Our ref: Mamre Road Data Centre Campus (SSD-92743706)

24 April 2026

Subject: Mamre Road Data Centre Campus – Additional matters for submissions report

Figure 3-3: Site Plan

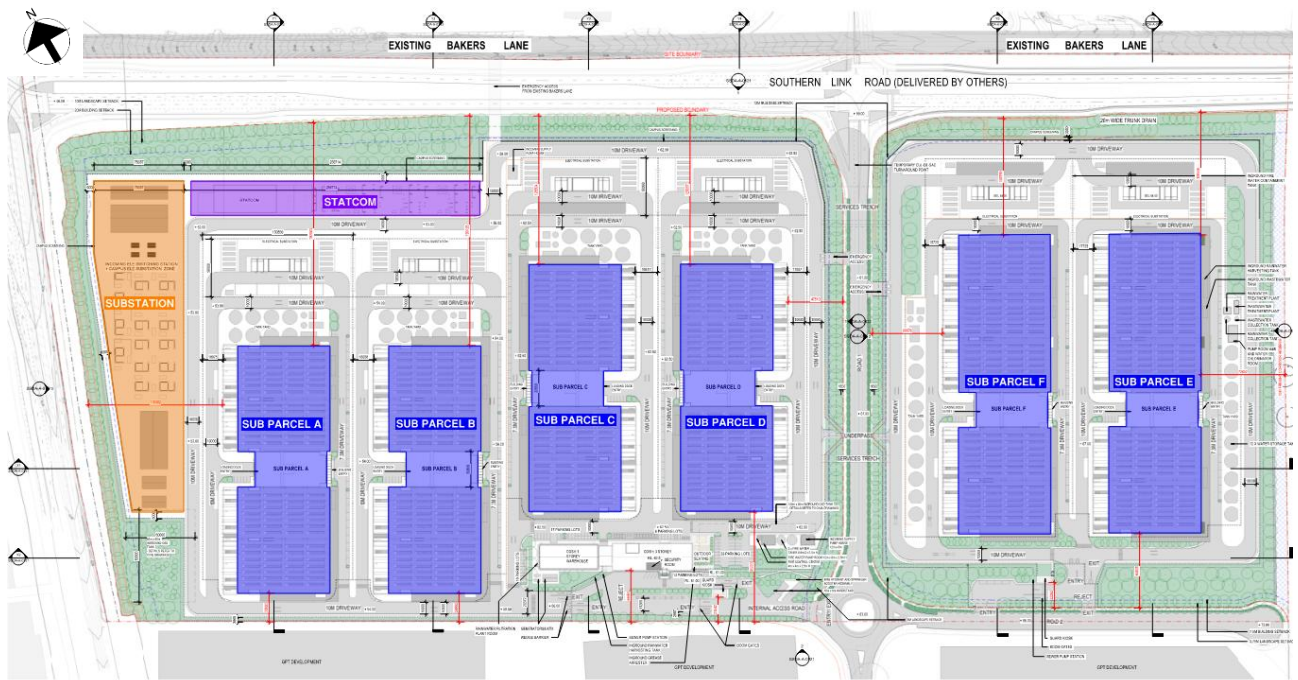
5. Section 4.2.6 of the MRP DCP stipulates the design of external storage areas should be behind front building setbacks and not visible from a public place. The proposed development proposes tanks fronting the Collector Road and the future SLR.

The Department requests that you provide further information on whether you are considering relocating the tanks and other storage infrastructure from within the front building setbacks to elsewhere on the site.

28. The architectural drawings are insufficiently labelled. Include labels for the diesel storage bulk and day tanks, batteries, fire water tanks, offices, high voltage transformers.

Bakers Lane Views - Data Centre Completion

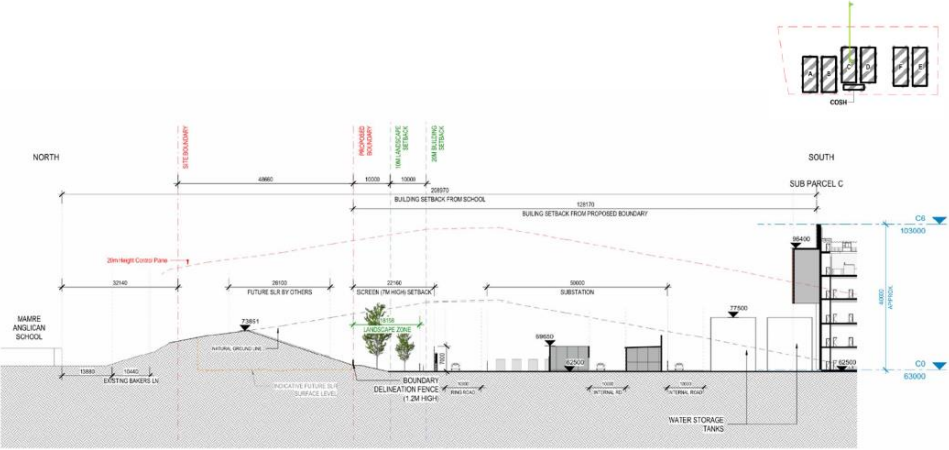
22. In addition to the above, the Department notes the photomontages presented from Bakers Lane (particularly Viewpoint 8) do not appear to accurately reflect the appearance of the development from this location, including the presentation of key elements such as the internal estate road and the proposed emergency access driveway (include any associated breaks in the proposed screening structure).
23. The photomontages provided in the VIA must be updated to give a realistic presentation of the development, noting the highest point of the development is 53 m above natural ground level.
